WIDEFIELD WATER AND SANITATION DISTRICT - BOOSTER 2 PUMP STATION
COUNTY OF EL PASO, STATE OF COLORADO
GRADING & EROSION CONTROL PLANS

PPR-21-069

FINAL GRADING / EROSION CONTROL PLAN

BLOCK 5
 WIDEFIELD COUNTRY CLUB
 ESTATES

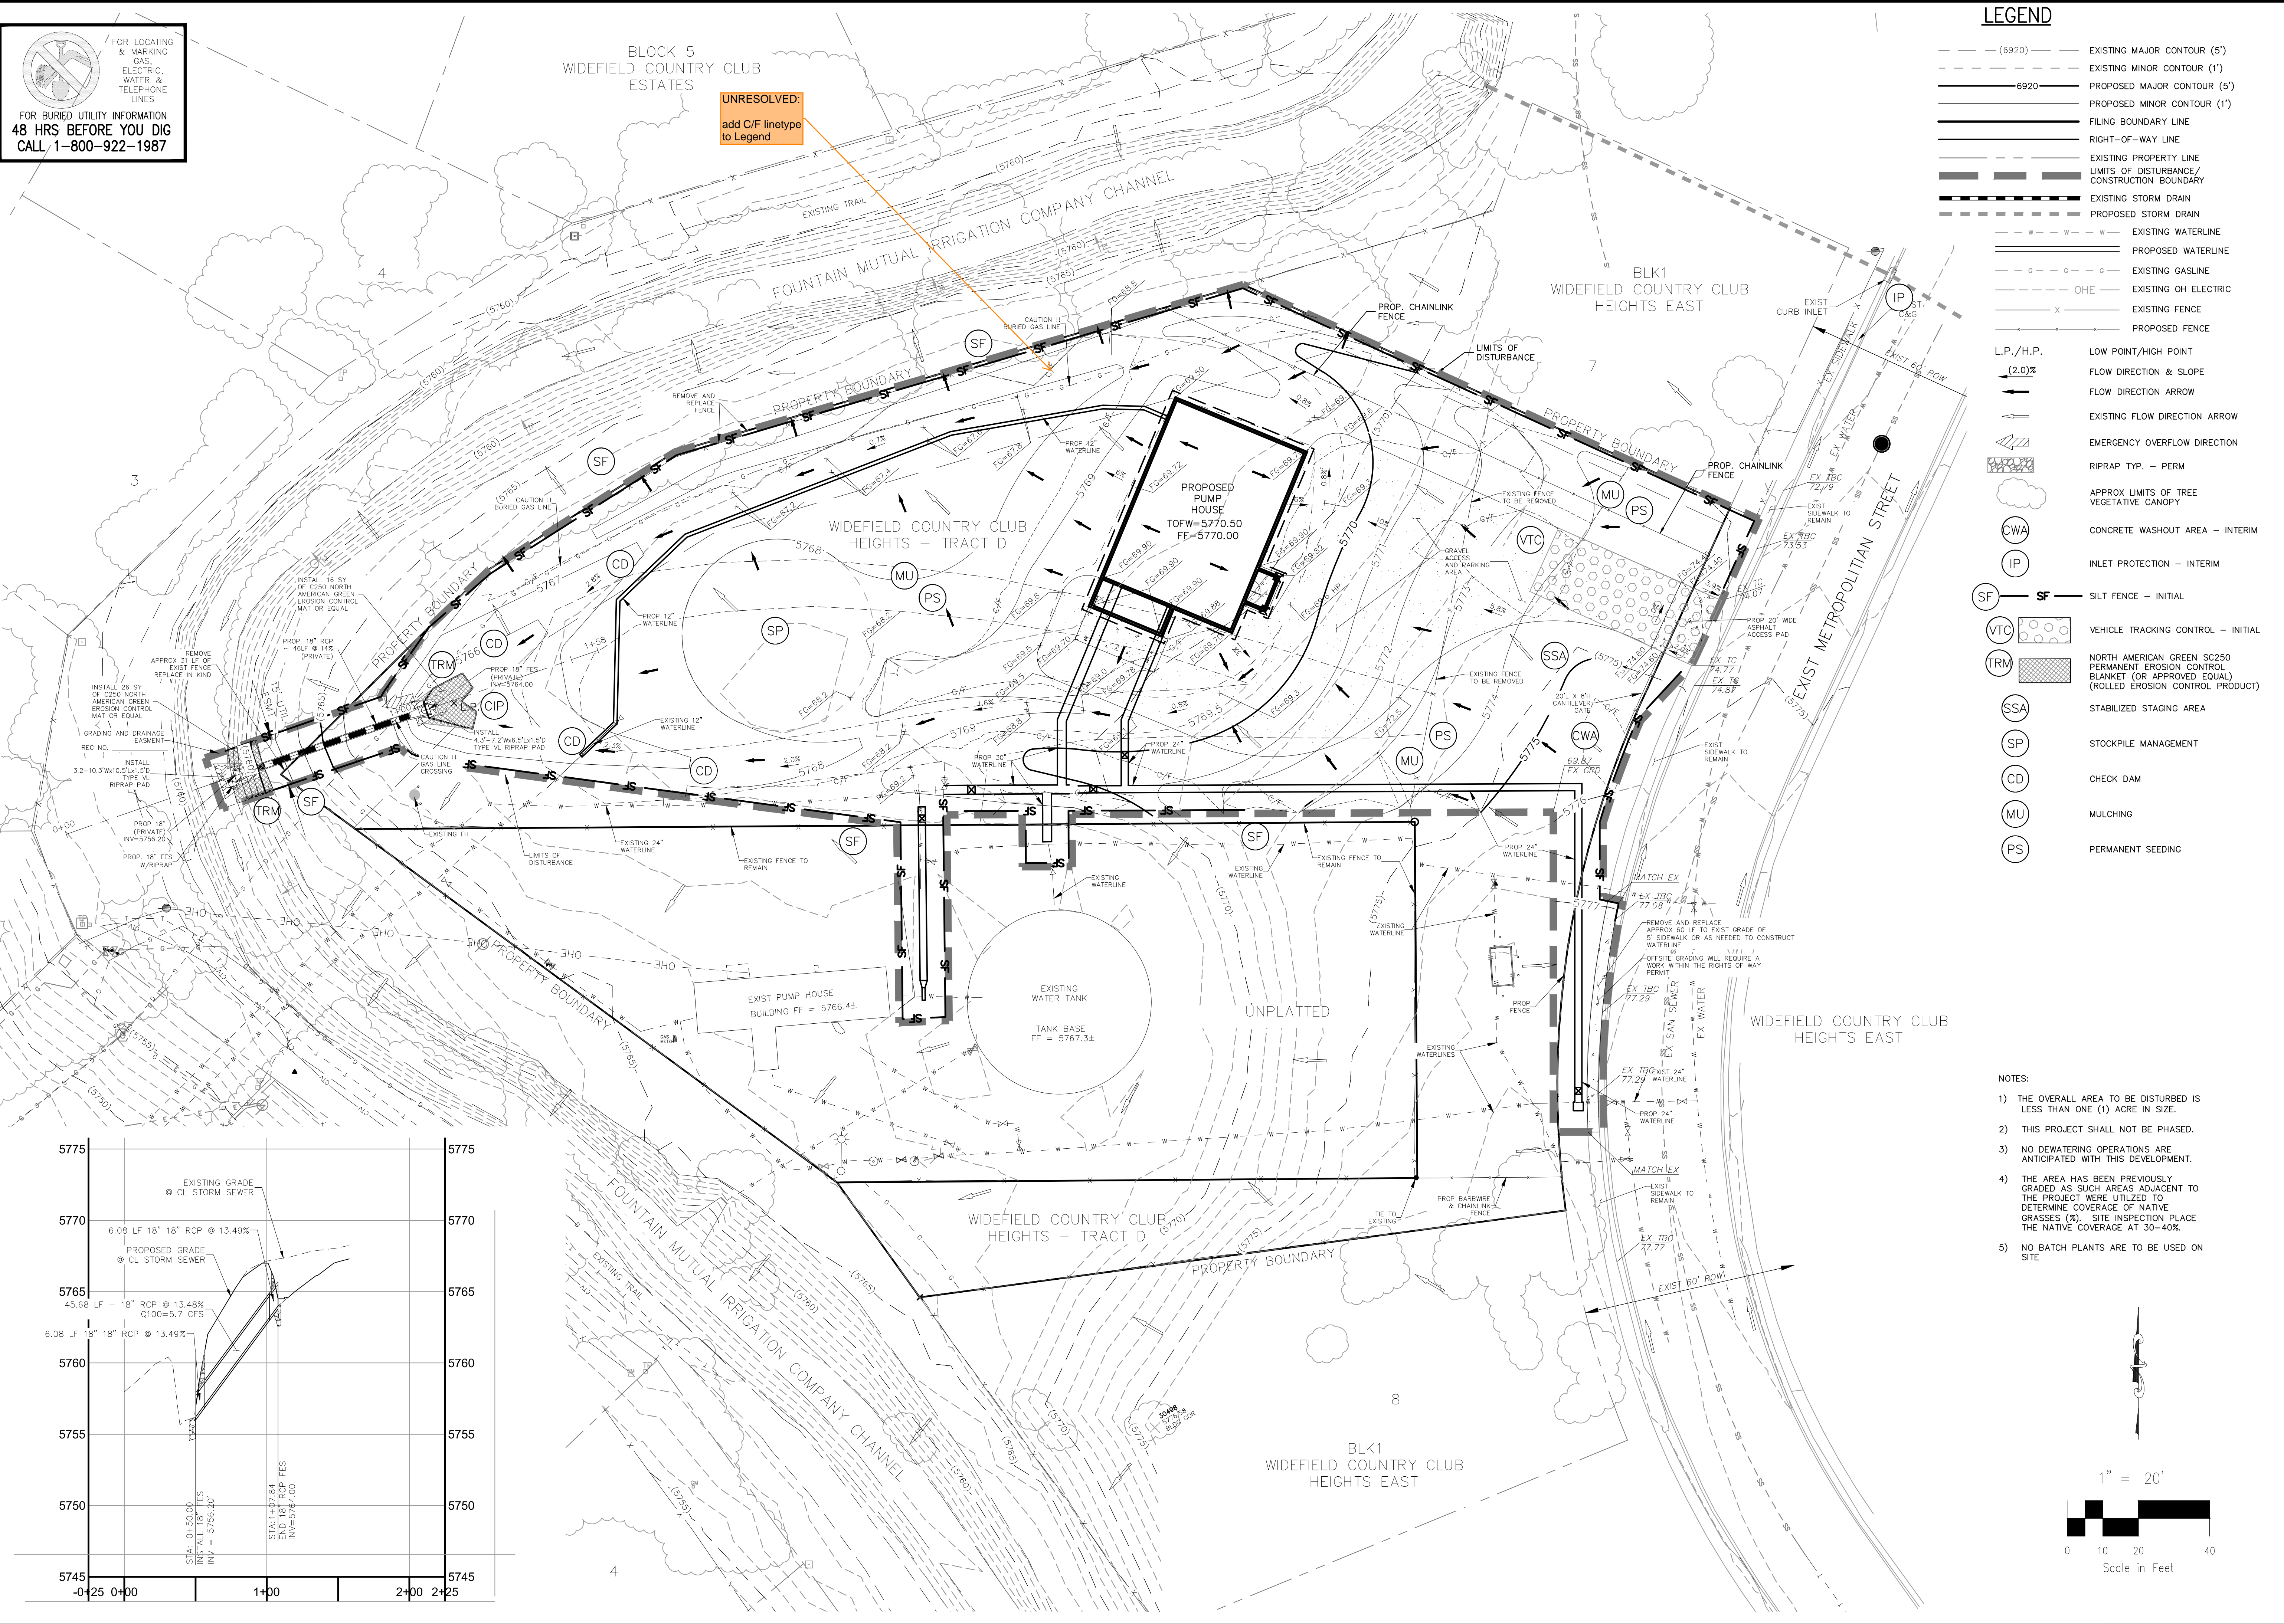
UNRESOLVED:
add C/F linetype
to Legend
